**ADC Planning Consultation
Response from the Historic Buildings Adviser**

Application Number	LU/338/11/L
Address	13a Western Road, Littlehampton
Description	Single storey rear extension.
Case Officer	Peter Cleveland
Site Visit

PROPOSED ELEVATION 1:50

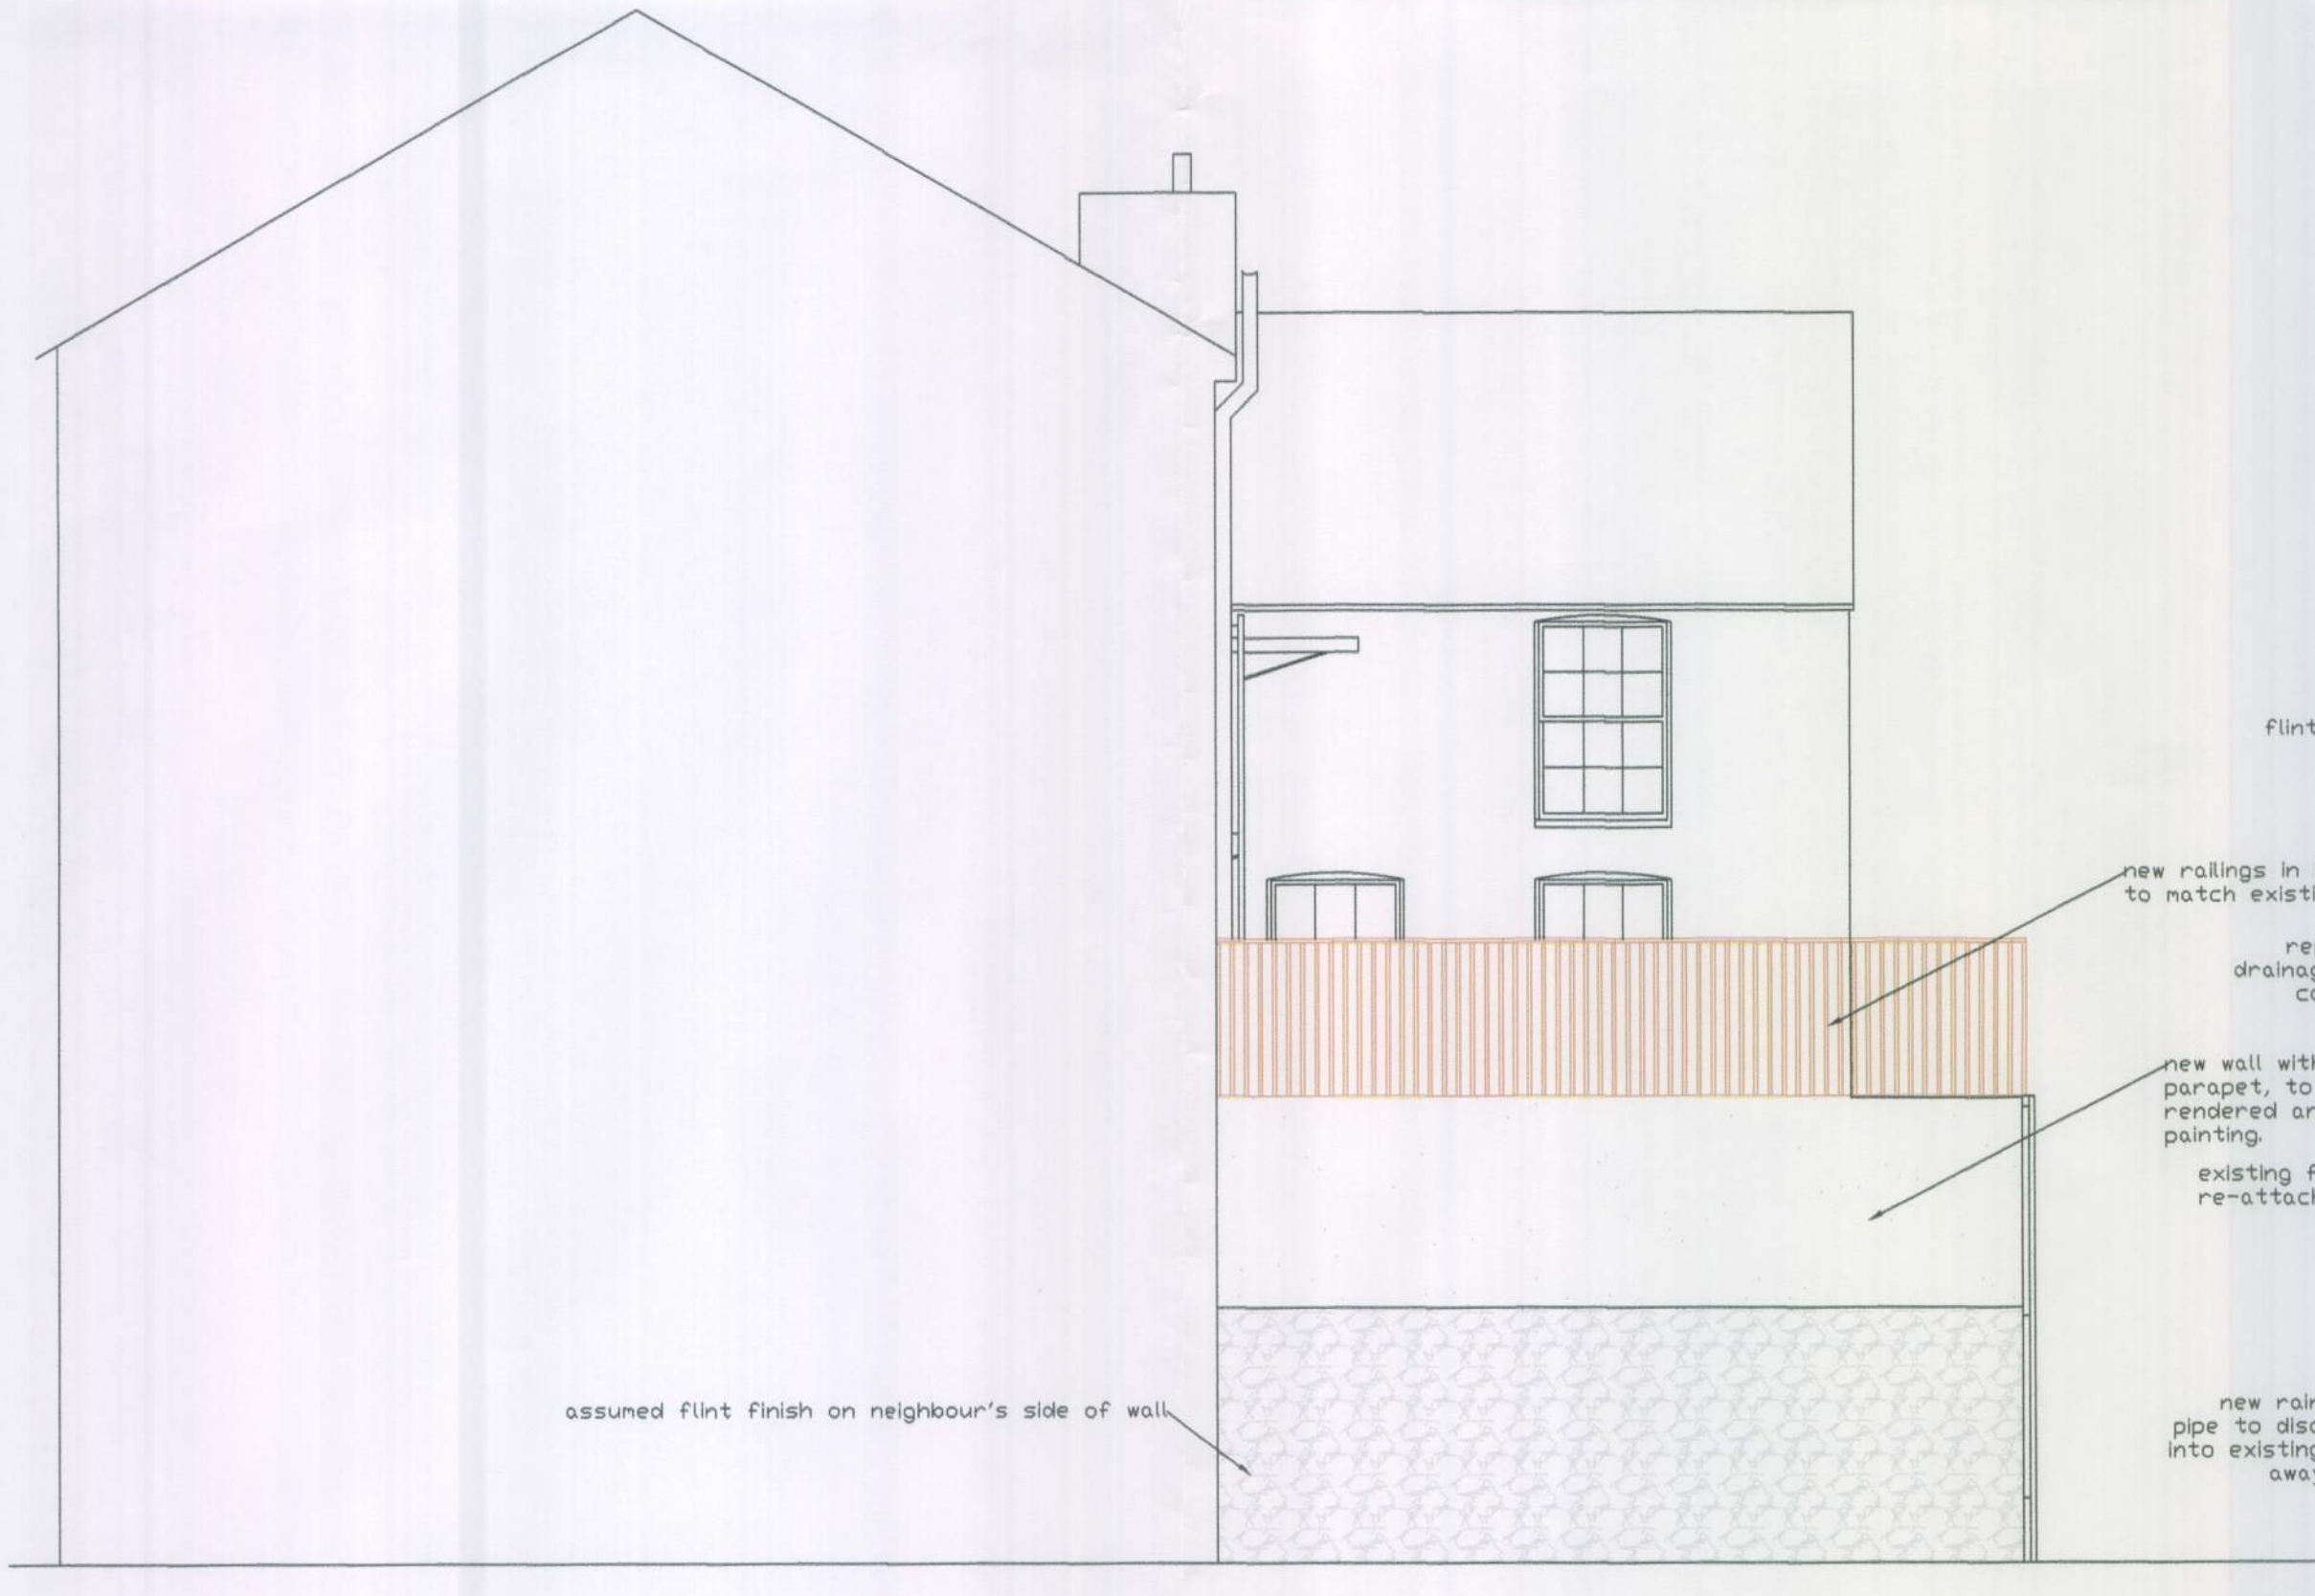
- The window between the bathroom and the proposed dining room should be retained to allow for reversability. The glazing could either be obscured, or the wall blocked on the bathroom side only. The window should remain visible.
- The railings should be removed if agreed to by building control. They are a potential distraction at this level.
- The rooflight should be an acceptable design for a listed building. I would suggest that a lantern is more appropriate and would look more sympathetic internally. Please provide details in due course.
- The parapet to the rear should have some form of detail between the elevation and the roof.
- The proposed addition abutts the neighbour's boundary wall but should not harm it in any way. Please provide details of the new structure and a method statement for its implementation.
- Please condition details of french doors.
